December 15, 2023

**Re: PA22-040 – 87th & 40th PRD – Technical Review 2
4218 / 4112 / 4018 / 3922 / NNA 87th Ave NE
CORE Project No. 21036**

The purpose of this letter is to provide a response to the review comments for PA22-040 – 87th & 40th PRD – Technical Review 2 - 4218 / 4112 / 4018 / 3922 / NNA 87th Ave NE dated October 24, 2023. We have addressed each comment and revised the plan/documentation accordingly. This letter contains the review comments immediately followed by our response to each in bold lettering.

OPEN SPACE CALCULATION

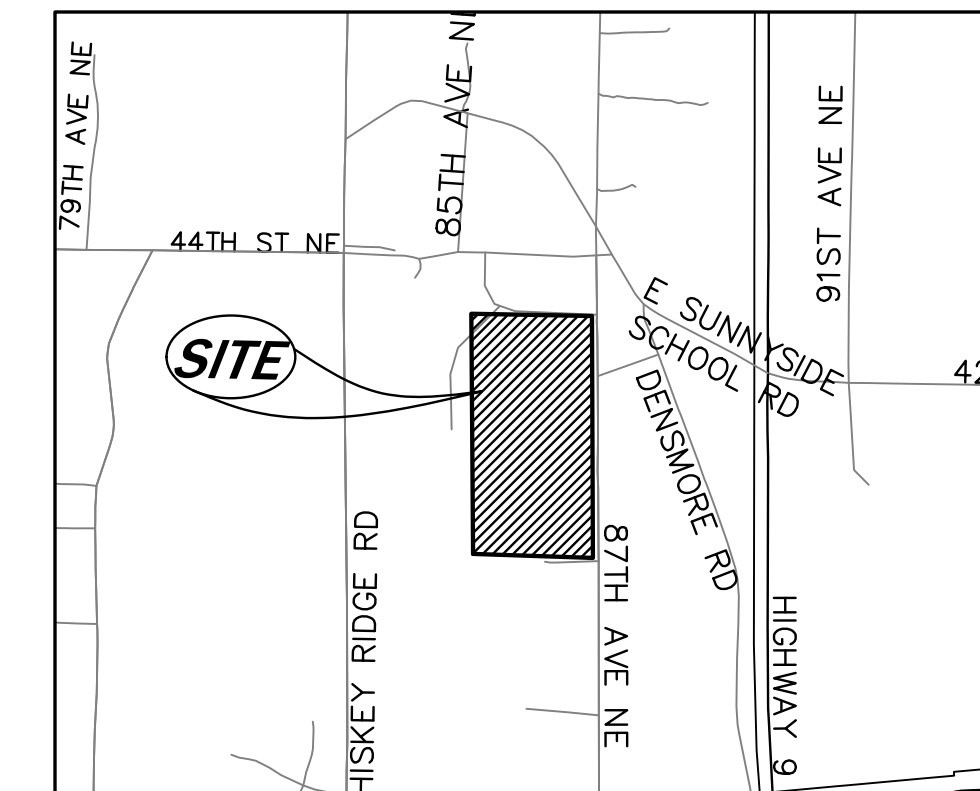
2. For clarity, in the table for "Open Space Calculations", please add a footnote that mentions Tracts B and G are not included. By omitting a reference to these tracts, it appears like an oversight for not including them.

- 2.1. Also due to the location and the size, Tract G should just be included into Lot 135.

Response: Footnote has been added for Tract B. No footnote has been added for Tract G since Tract G no longer exists per comment below.

Response: Tract G has been included into Lot 135 as suggested.

SHEET	OF
C7.21	30

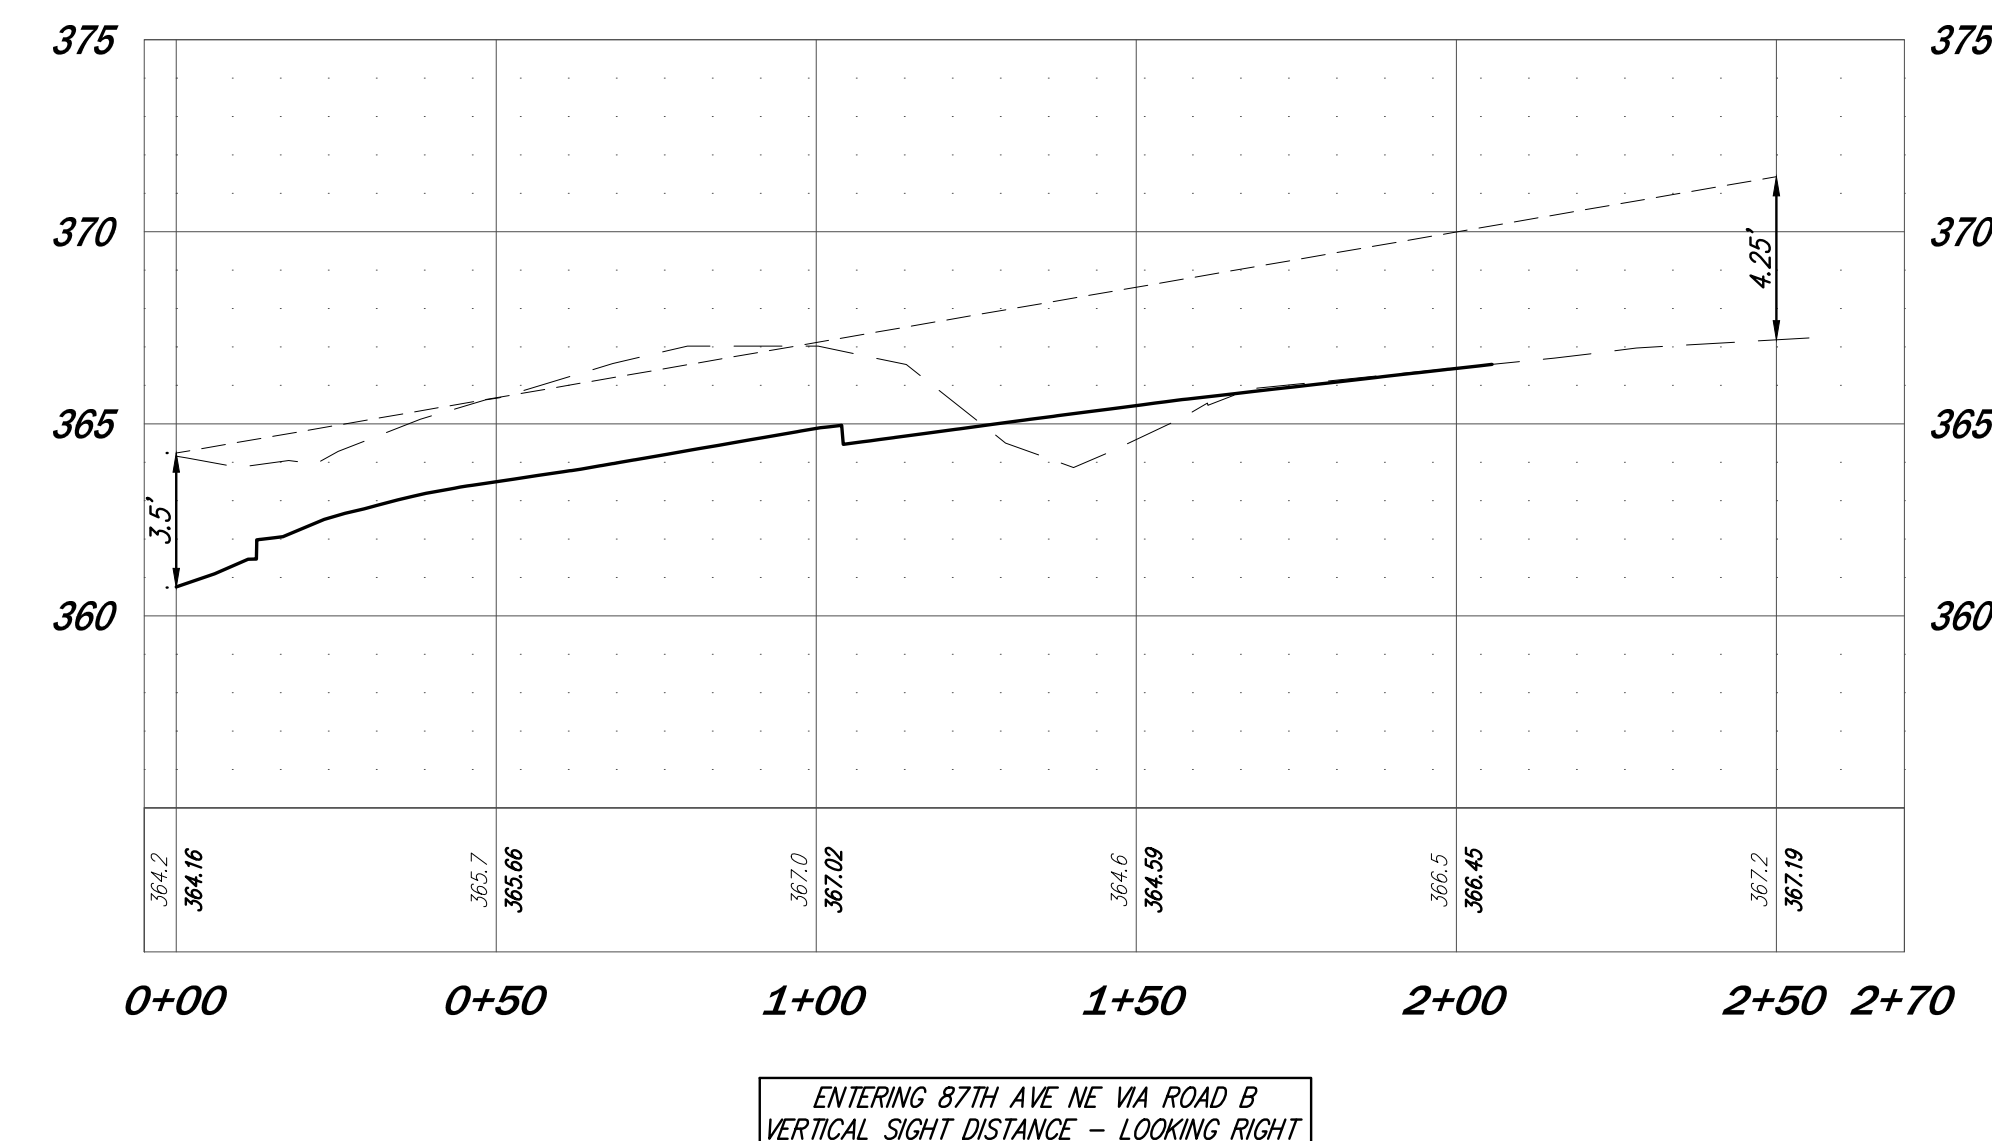
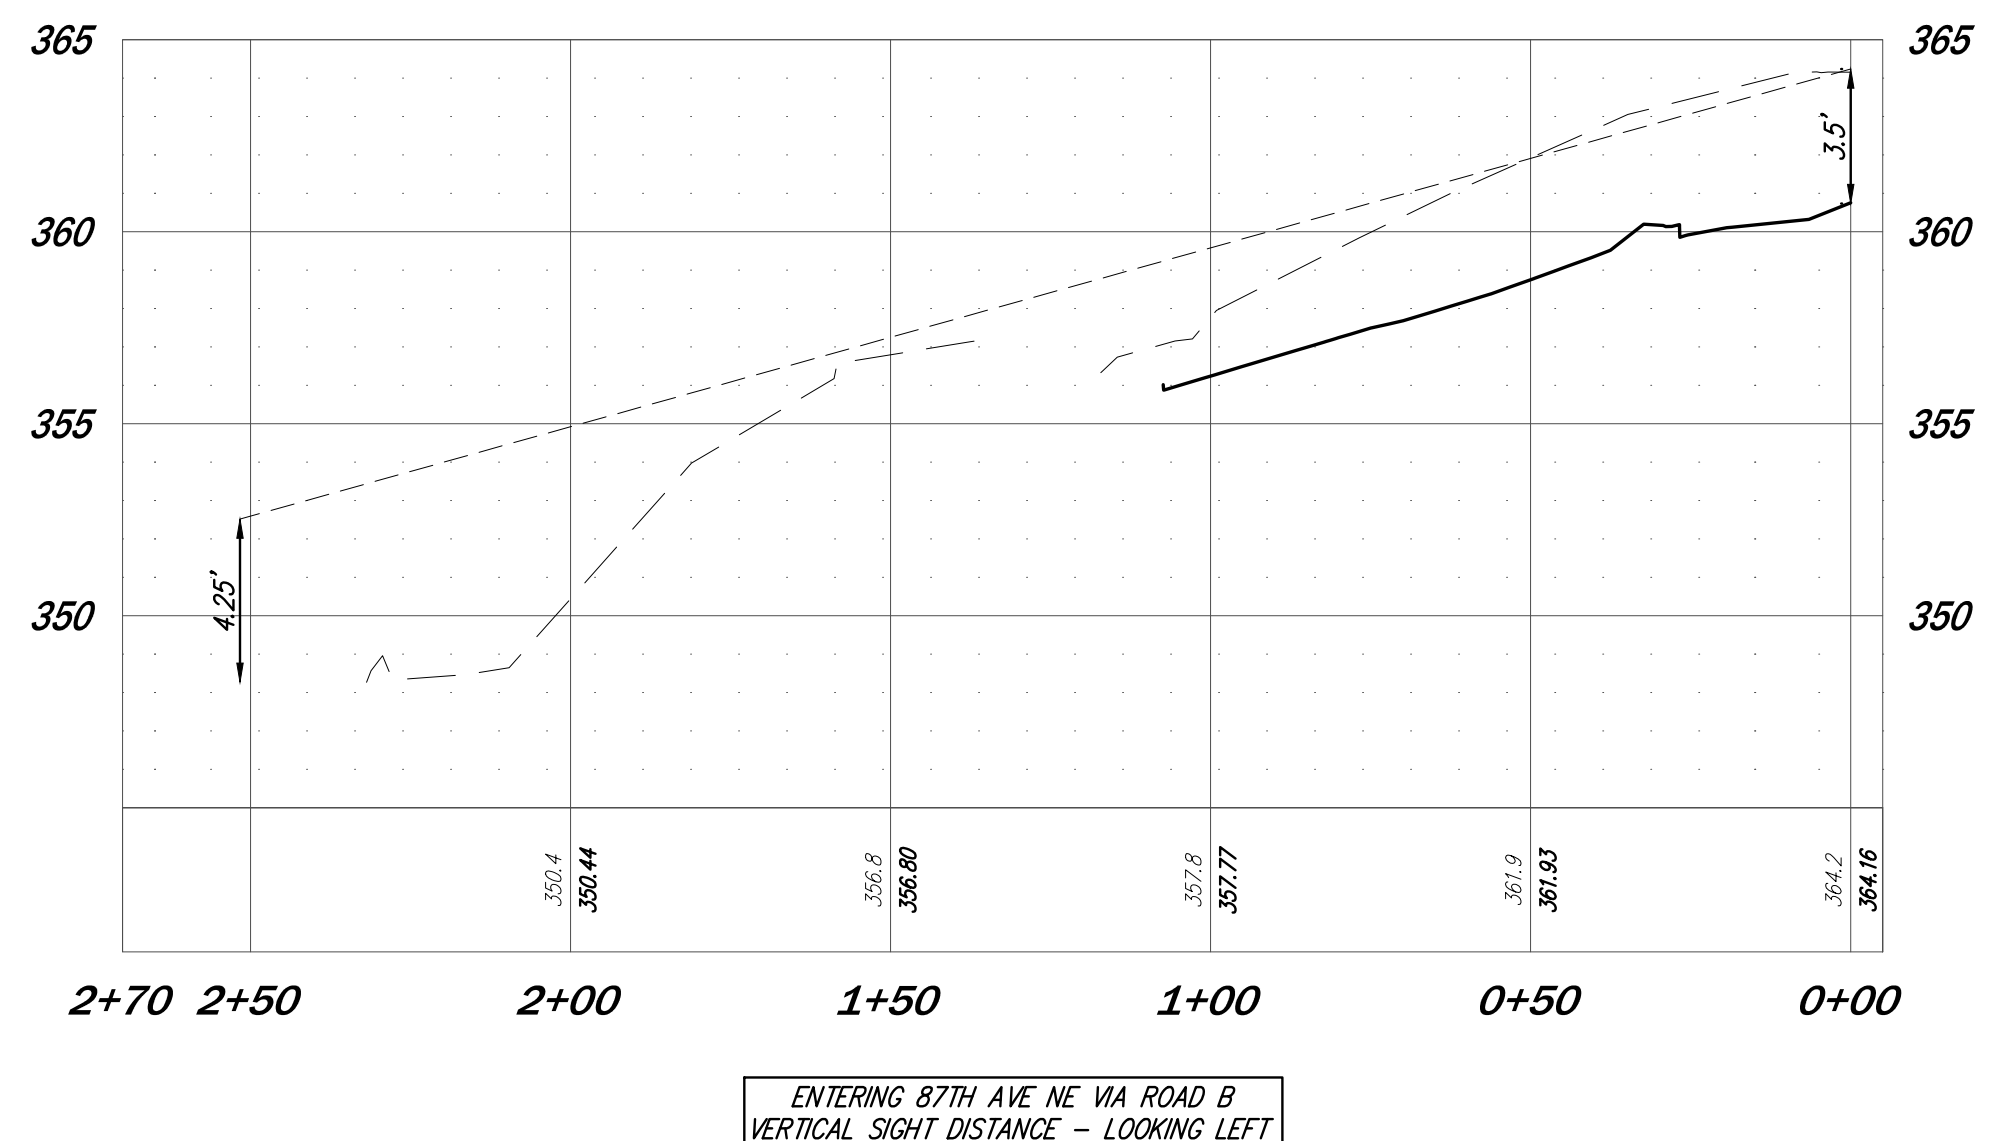
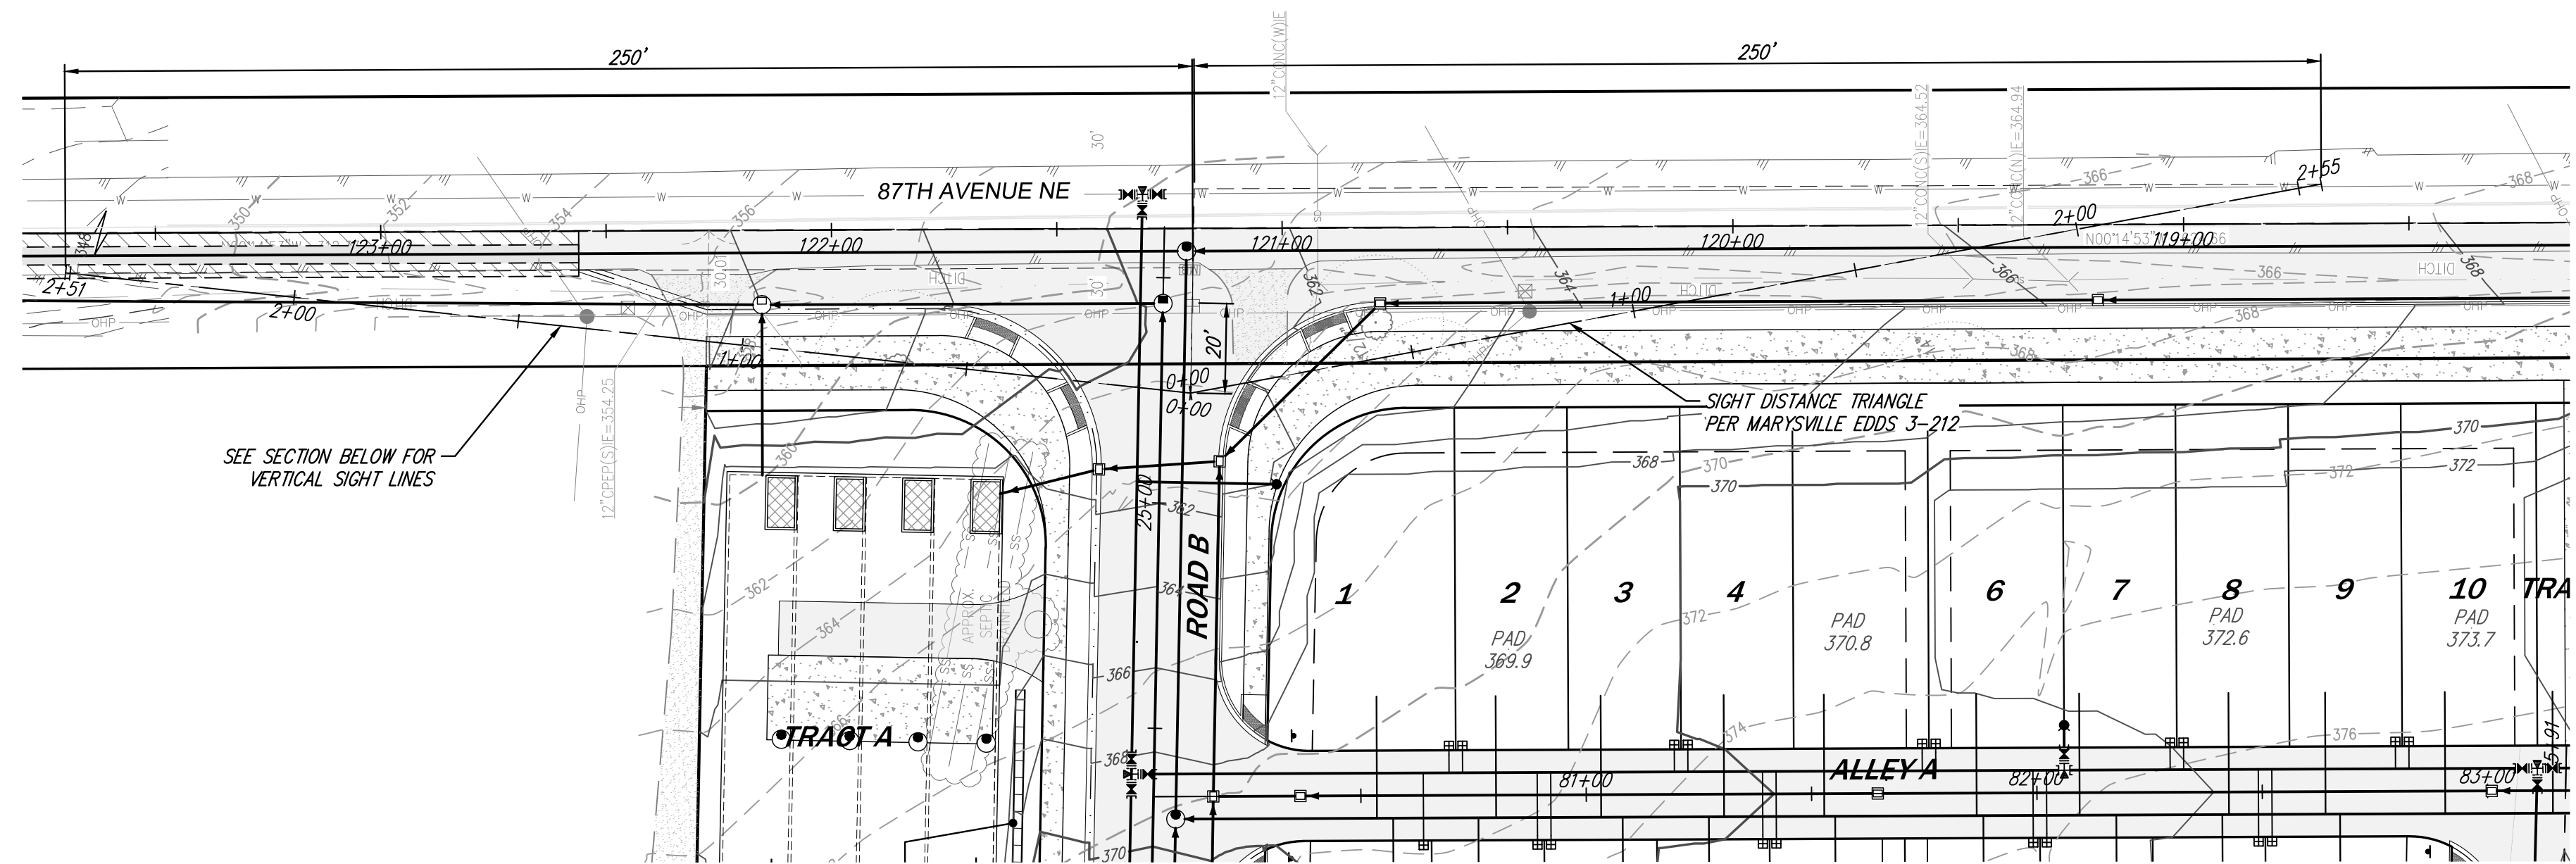
3. **Hydrants** - additional hydrants need to be installed at the following locations:
 - 3.1. At the intersection of 40th St and Road F – SW corner preferred.
 - 3.2. Midway down north section of alley A, near lot 131.
 - 3.3. Midway down south section of alley A, near lot 120.

4. **Access** - Signage stating “NO PARKING – FIRE LANE” needs to be installed on both sides of any 20’ wide roadway.

Response: Hydrants have been placed in the areas as referenced.

Response: “No parking – Fire Lane” signage is shown for all 20’ wide roadways on sheets C7.01-C7.03.
